**KIRKLEES METROPOLITAN COUNCIL
INVESTMENT & REGENERATION SERVICE**

| Reference No: | 2024/62/92846/W |
| Site Address: | 45-47, Church Lane, Moldgreen, Huddersfield, HD5 9EB |
| Description: | Change of use of dwelling to house of multiple occupation |

1 Ground Floor Proposed
1 : 50

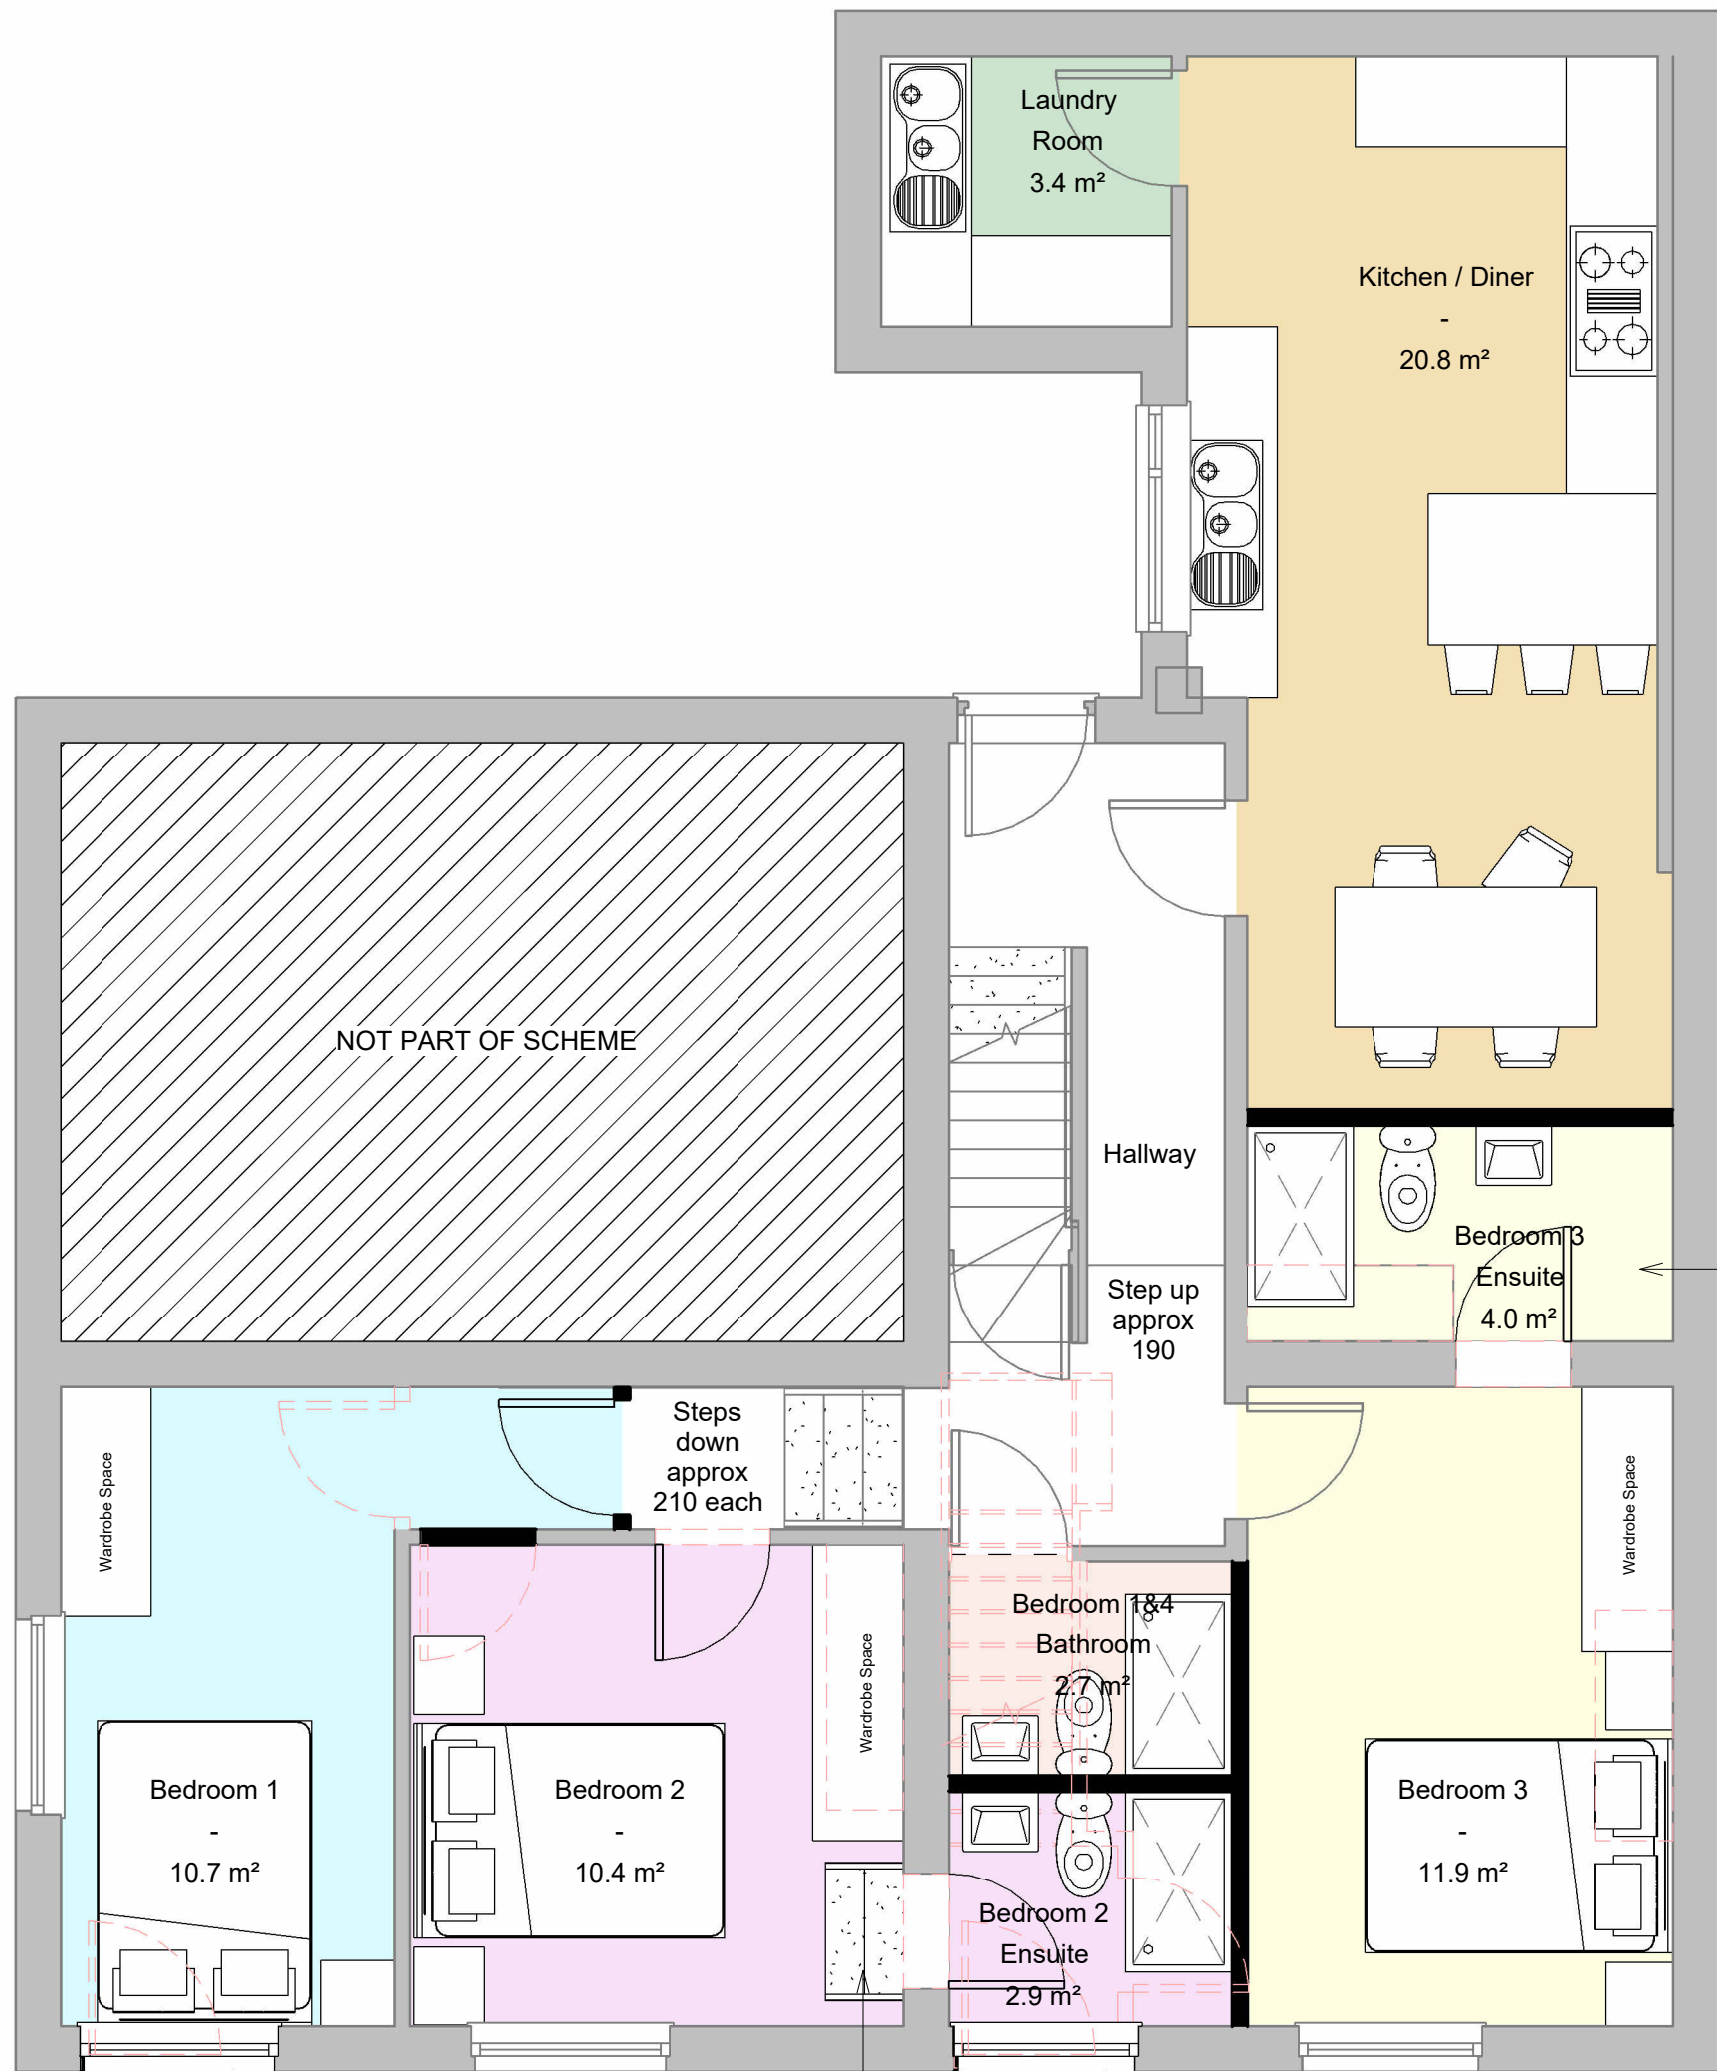
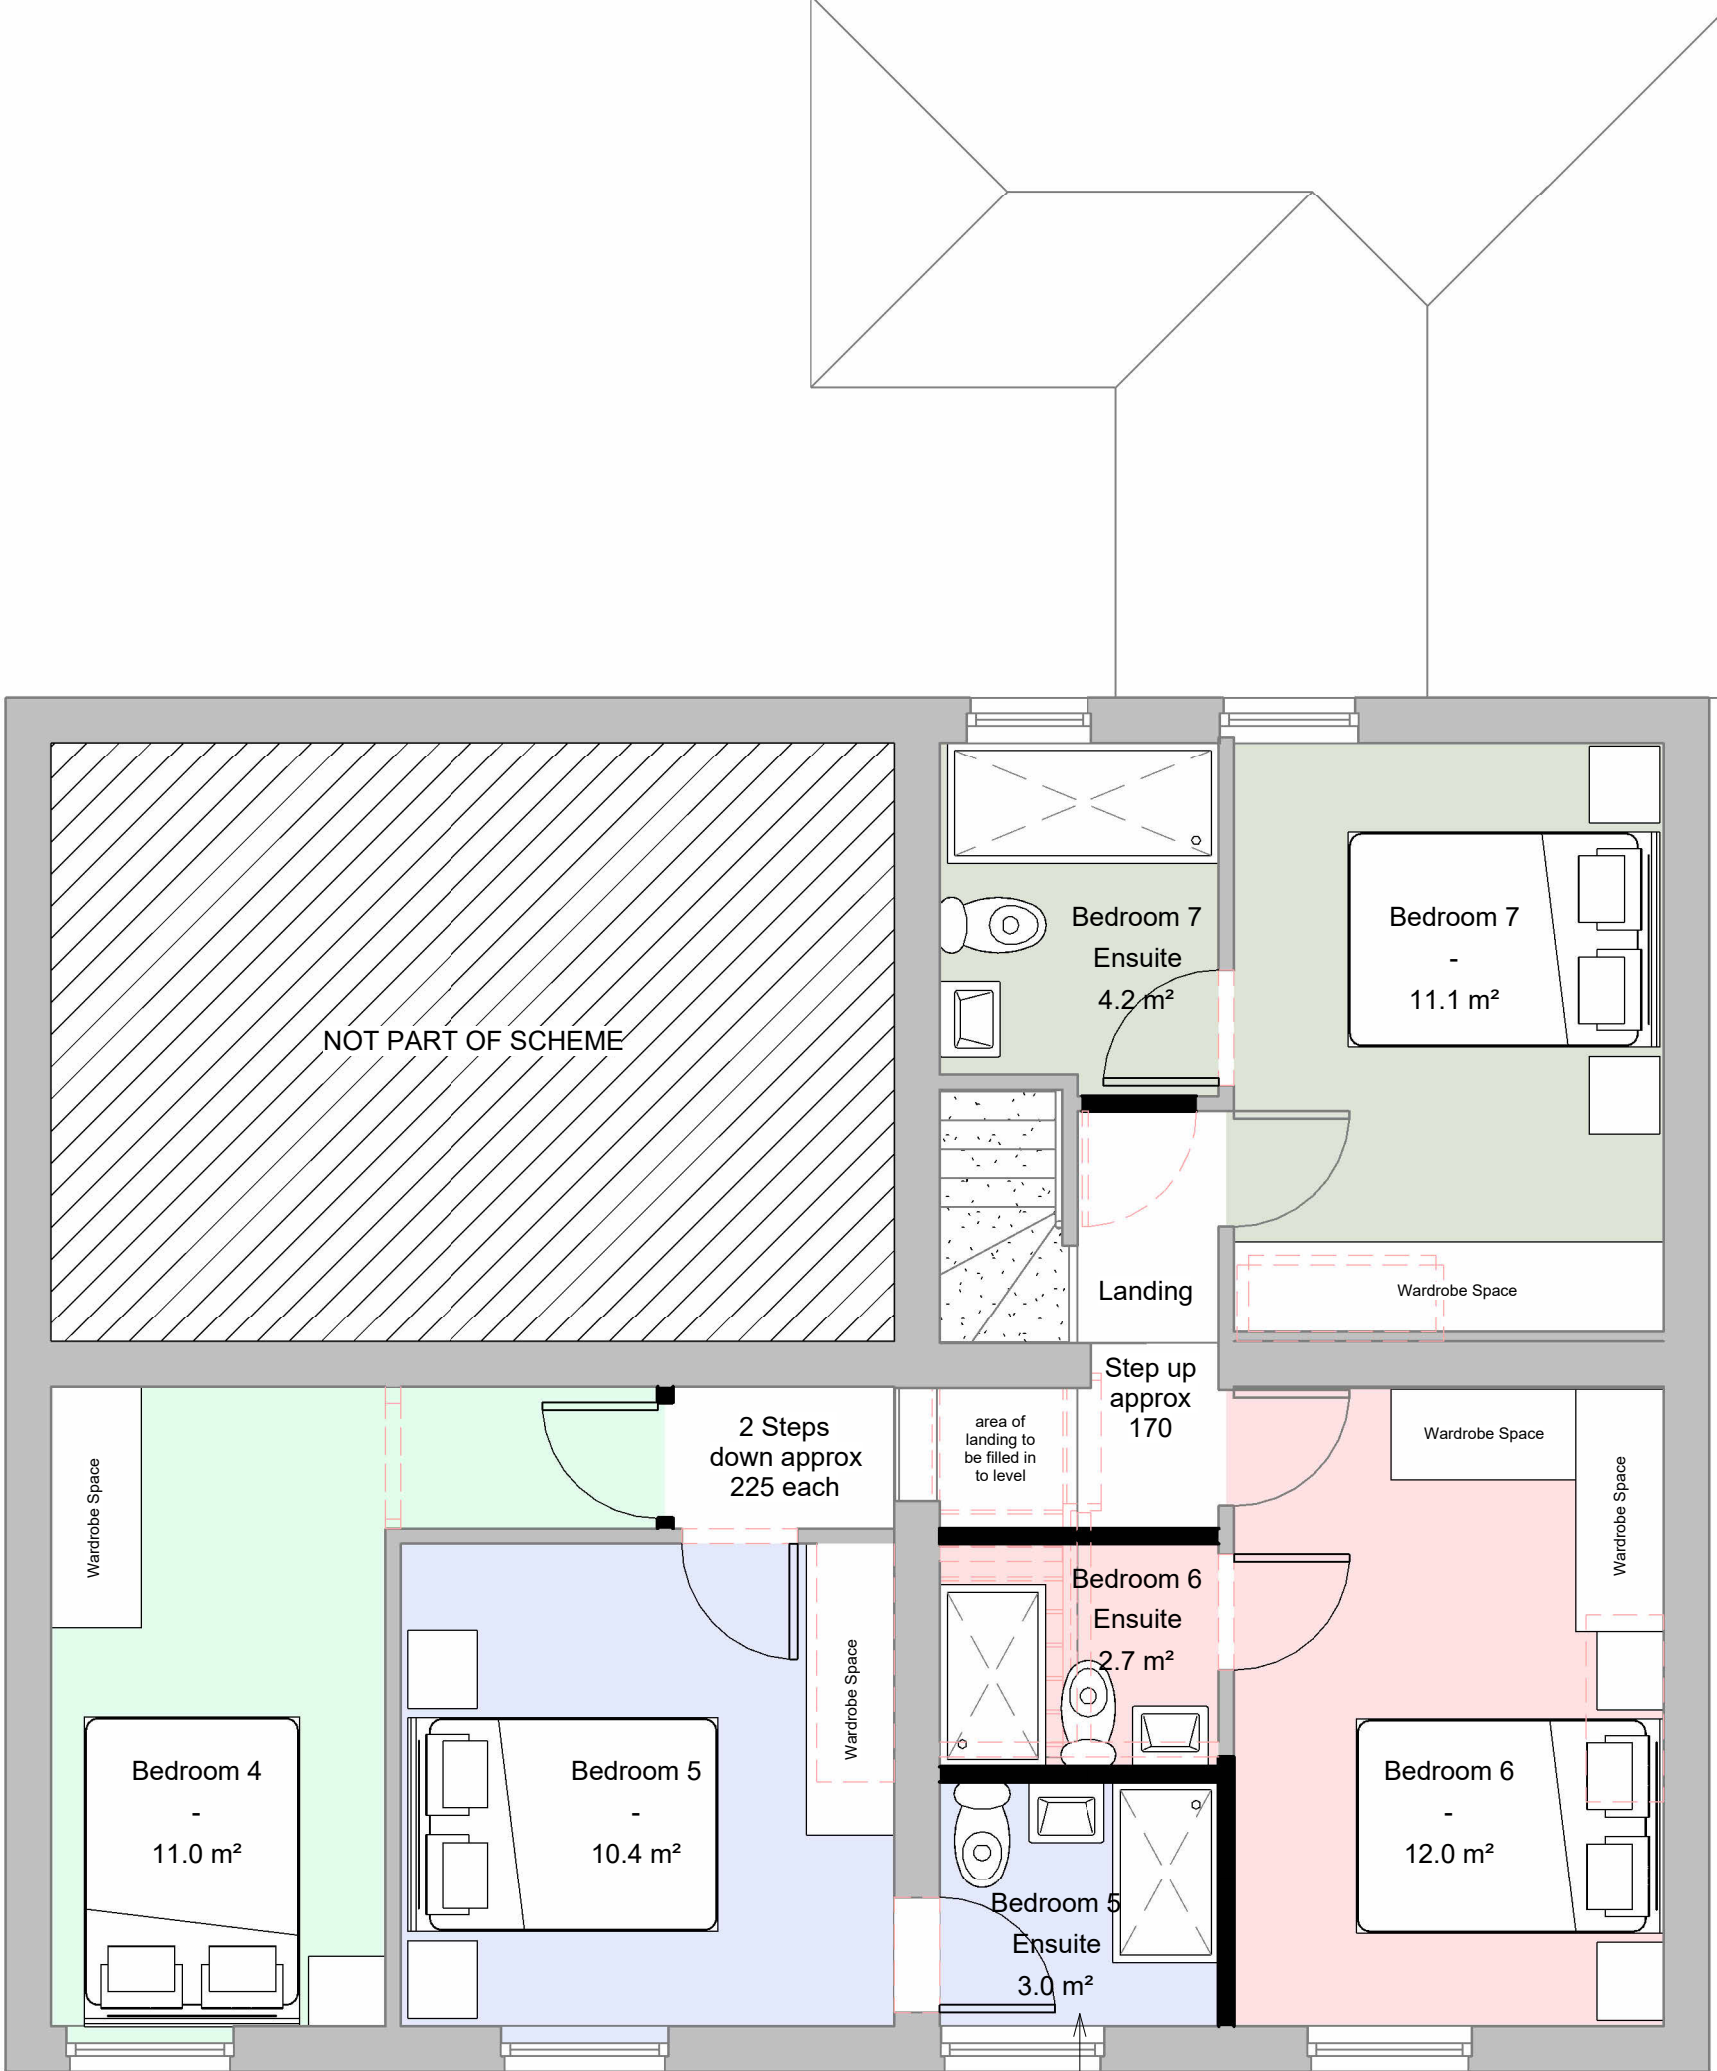
The submitted floor plans show the bedrooms to have the following internal floor areas:

- Bedroom 1 – 10.7m²
- Bedroom 2 – 10.4m²
- Bedroom 3 – 11.9m²
- Bedroom 4 – 11.0m²
- Bedroom 5 – 10.4m²
- Bedroom 6 – 12m²
- Bedroom 7 – 11.1m²

Whilst officer's note that the internal floor areas as set out above are compliant with the standards for double bedrooms, upon any grant of approval, a condition shall be imposed to limit the level of occupation to 7 persons.

The aforementioned document assesses shared accommodation and states each living room should have a minimum living room size of 8m² plus an additional 1m² per person. Which would mean this HMO would require a living room size of at least 15m². The kitchen / diner area shown on the floorplans is 20.8m². Whilst officer's note that this shared area is larger than the minimum required, it is still considered appropriate in this instance to limit occupation to 7 persons for reasons mitigating the potential for overcrowding.

3. Notwithstanding the submitted details, at no time shall there be in excess of 7 person(s) utilising the application site for accommodation.
Reason: In the interests of the amenity of the occupiers, to avoid overcrowding and to ensure that the communal living areas are sufficient for the level of occupancy, and for reasons of highway safety as well as safety and security in accordance with Policy LP21, LP22 & LP24b of the Kirklees Local Plan, Principle 16 of the Housebuilders Design Guide SPD and Chapter 12 of the National Planning Policy Framework.

3 (North) Front Elevation as Proposed
1 : 100

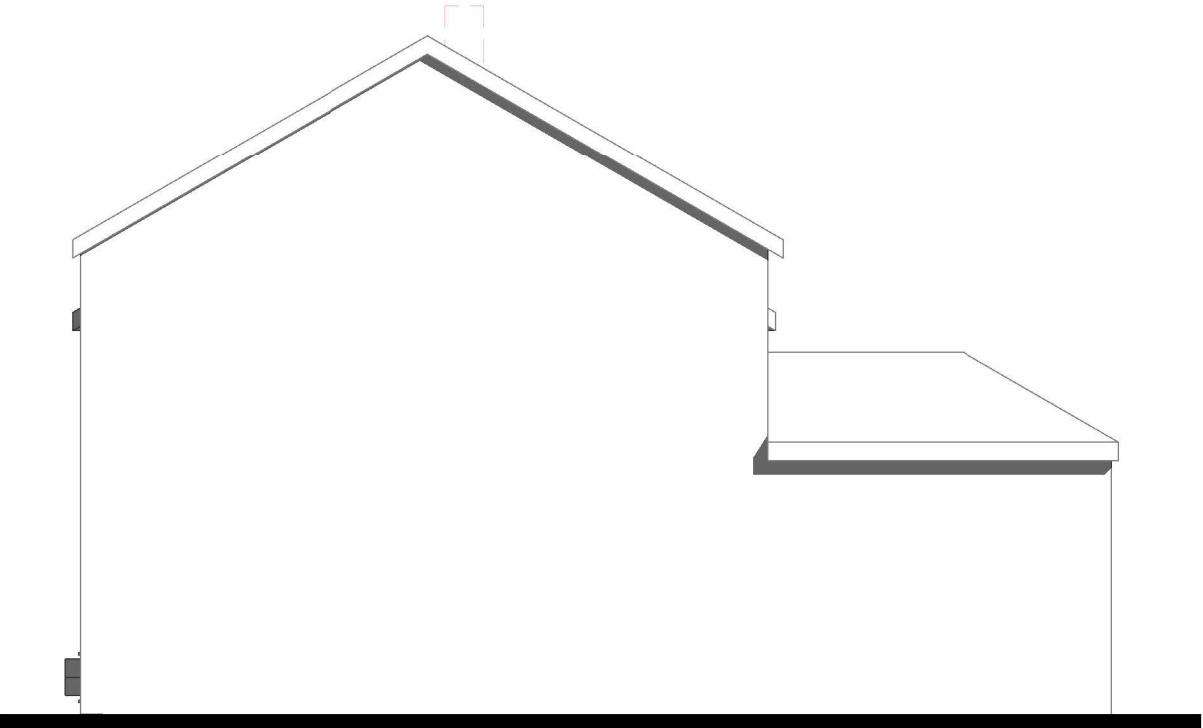
The only external alteration proposed is the replacement of the existing doorways to the front elevation with windows. Upon any grant of approval, a condition would be imposed to ensure that the design of the replacement windows match the existing windows to 45-47 Church Lane.

The two additional windows proposed will serve a bedroom and bathroom. Given that this bedroom window would be a second window for 'bedroom 1', upon any grant of approval, a condition shall be imposed to obscurely glaze the two new windows in the front elevation. This condition is to be imposed due to the separation distance between these proposed windows and the dwellings directly opposite.

4. The development shall not be occupied until the two new windows in the north / front elevation of the building hereby approved have been obscure glazed. The obscure glazing shall thereafter be retained for the lifetime of the development.
Reason: In the interests of the amenity of the occupiers of neighbouring properties to accord with policy LP24 of the Kirklees Local Plan, Principle 3 of the adopted SPD on House Extensions and Alterations and Policies within Chapter 12 of the National Planning Policy Framework.

5. The two new windows in the north / front elevation of the building hereby approved shall match the appearance of the existing windows at 45-47 Church Lane, including the same material and colour finish.
Reason: In the interests of visual amenity and to accord with Policies LP24 of the Kirklees Local Plan, Chapter 12 of the National Planning Policy Framework and Principle 13 of the Housebuilders Design Guide Supplementary Planning Document.

Proposed Site Plan

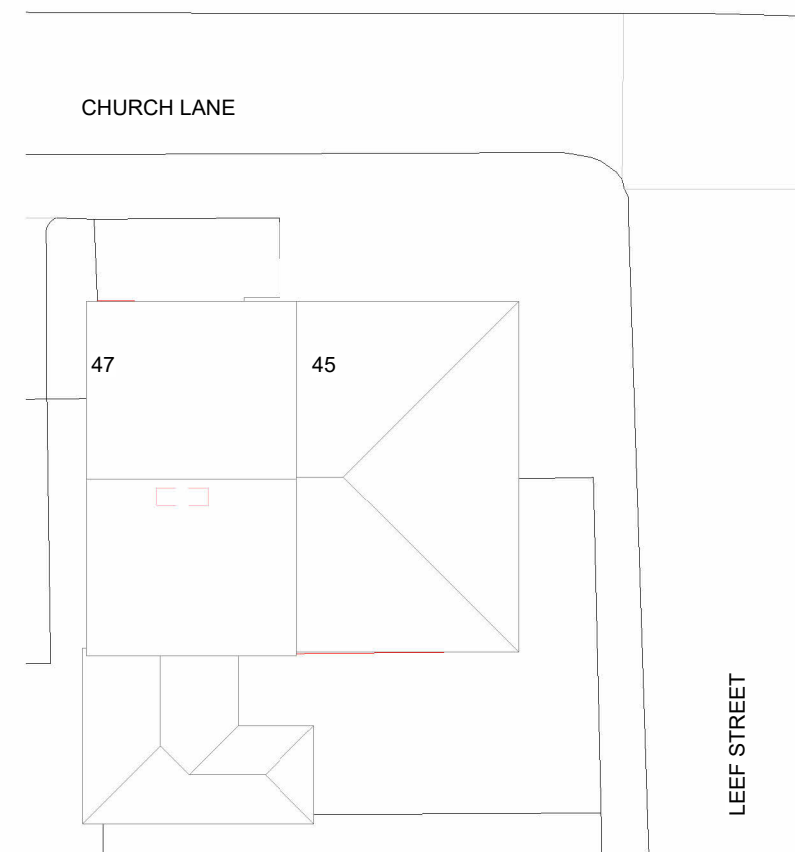
Bin storage arrangements are as existing and are considered adequate. No cycle parking is shown, although there is scope for cycle lockers/storage to be provided in the yard area adjacent to the gable end of number 2 Leef Street and this can be conditioned.

6. The development shall not be brought into use until a scheme detailing cycle parking facilities has been submitted to and approved in writing by the Local Planning Authority. The approved cycle parking facilities shall be provided prior to first occupation of the development and retained thereafter for the lifetime of the development.
Reason: In the interests of highway safety, to accord with Policy LP21 of the Kirklees Local Plan and Chapter 12 of the National Planning Policy Framework.
